RE: Veterans Affairs National Cemetery Traffic Impact Analysis (G06D001)
Response to City of Albuquerque Comments

DATE: September 10, 2024

The purpose of this memorandum is to respond to the City of Albuquerque's comments dated August 26, 2024 regarding the Traffic Impact Analysis for the proposed Veterans Affairs National Cemetery (dated May 21, 2024). Each comment is provided below along with our response.

ATRISCO VISTA BOULEVARD ROAD IMPROVEMENT PLANS

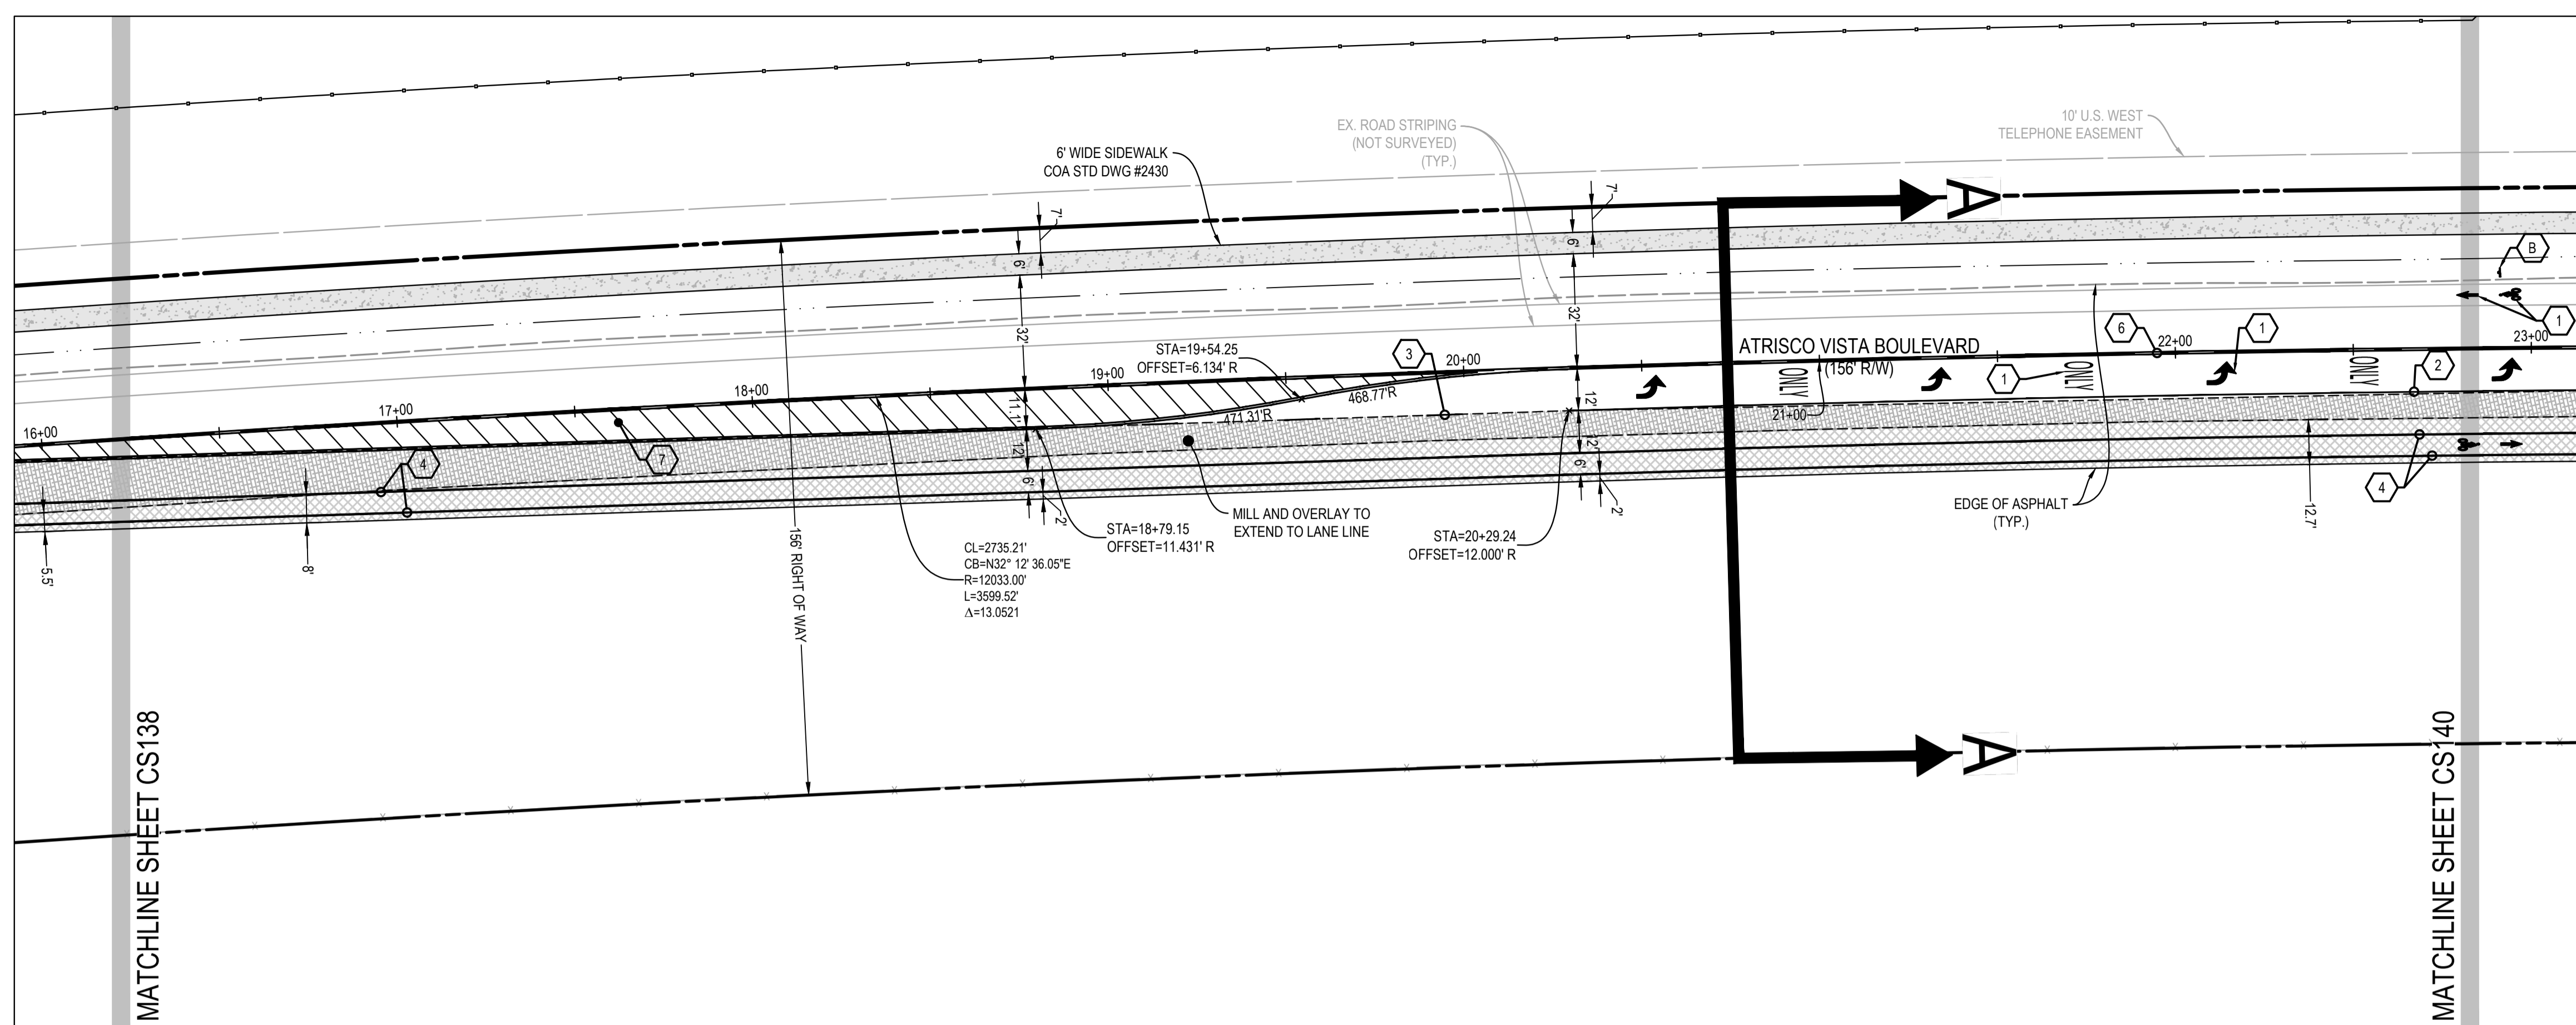
Comment 5: The city concurs with the 300-foot left turn lane on northbound Atrisco Vista Blvd at the main entrance, however, per the DPM the transition is a 150-foot reverse curve.

Response 5: Noted. The left turn lane will be designed with a 150-foot reverse curve transition.

SCALE:	HORIZ.: 1" = 30'
	VERT.: N/A
DATE:	MAY 2024
JOB:	5041-0101
DRAWN:	CTW
CHECK:	BJS
CADD:	CT201.DWG
NCS:	CS143
SHEET:	09 OF 23

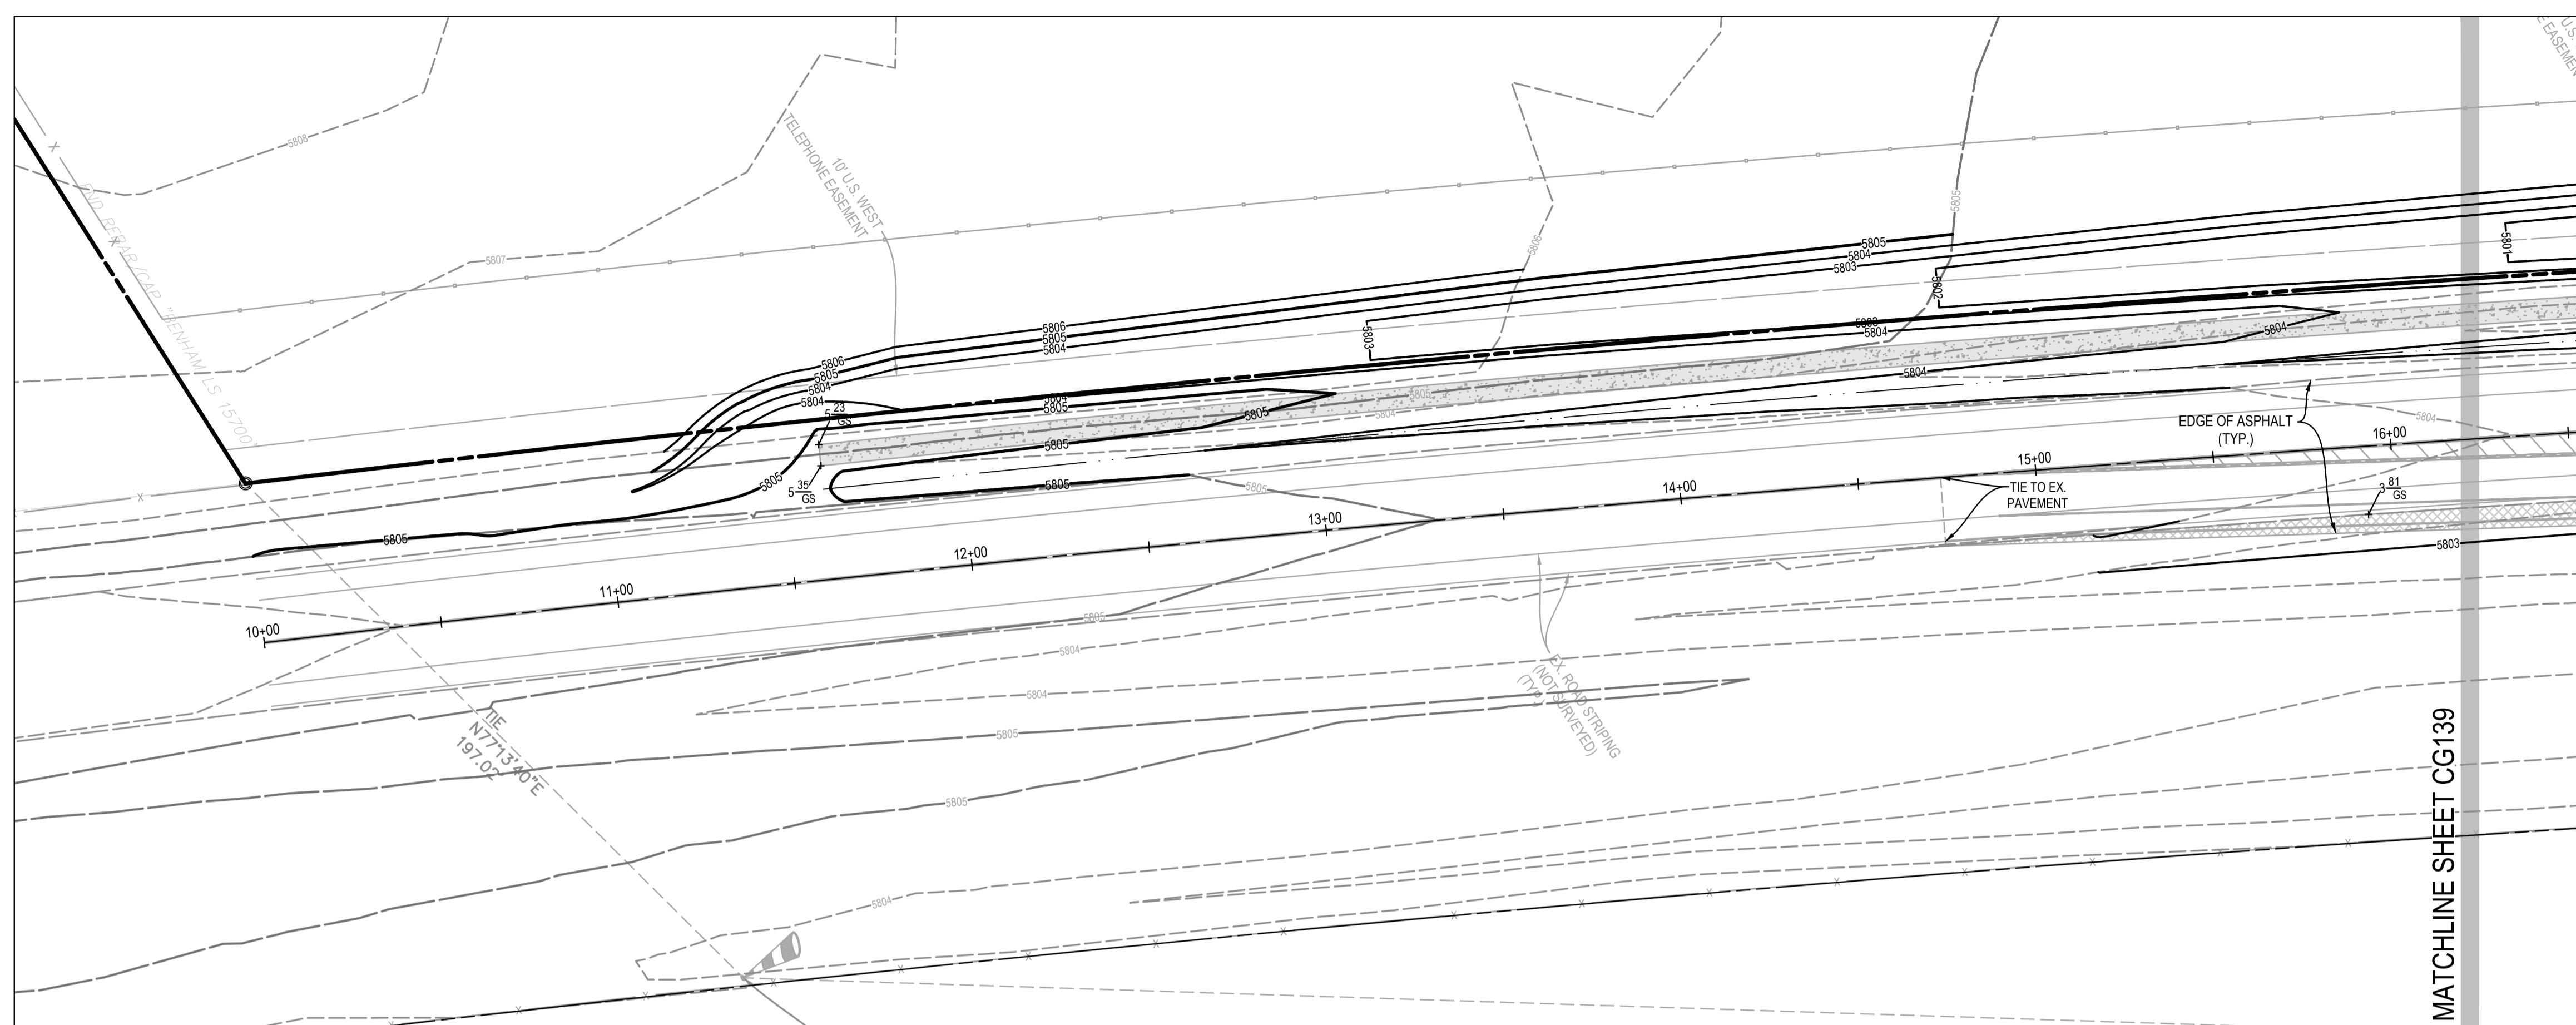
Comment 6: To minimize conflict points, it is preferable to only have one driveway on Shooting Range Road. It appears the location of “Service Entrance” on the Conceptual Site Map is directly across the road from Aerospace Pkwy, which is an acceptable location.

Response 6: The secondary service road on Shooting Range Road is critically important to the long-term and short-term operation of the cemetery for the following reasons:

- The cemetery construction will start with an initial smaller phase to allow the cemetery to open in time to avoid depletion of available burial types to veterans in the greater Albuquerque/Sante Fe region. This first phase will include construction of the paved primary service entrance on Shooting Range Road and installation of temporary trailers to allow the cemetery to begin operations quickly and serve the public and veteran families. The main entrance on Atrisco Vista Road will not be completed prior to this initial phase. Therefore, in order to keep cemetery visitors and staff separate from the on-going construction traffic, the western entrance on Shooting Range will function as the construction entrance.

- After the full cemetery construction is complete and all entrances open, the cemetery needs to maintain the secondary service entrance on Shooting Range Road to keep future construction material deliveries off of the paved cemetery visitor roads to avoid damaging the roadways and to maintain the shrine standards that all national cemeteries strive to achieve and maintain.

- The cemetery operations require outside contractors who are not able to access the VA maintenance yard. The secondary service entrance would provide access for those outside contractors when normal cemetery operations are closed and other entrances are locked.

- The cemetery will expand every 10 to 15 years for the next 100 years. The secondary service entrance on Shooting Range Road will serve as the future construction access to ensure that construction vehicles do not disrupt the cemetery operations when future expansions occur.

There is flexibility to shift the secondary service entrance on Shooting Range Road to the east or the west, if desired; however, for the reasons cited above the access is critical for the operation and on-going development and expansion of the cemetery.
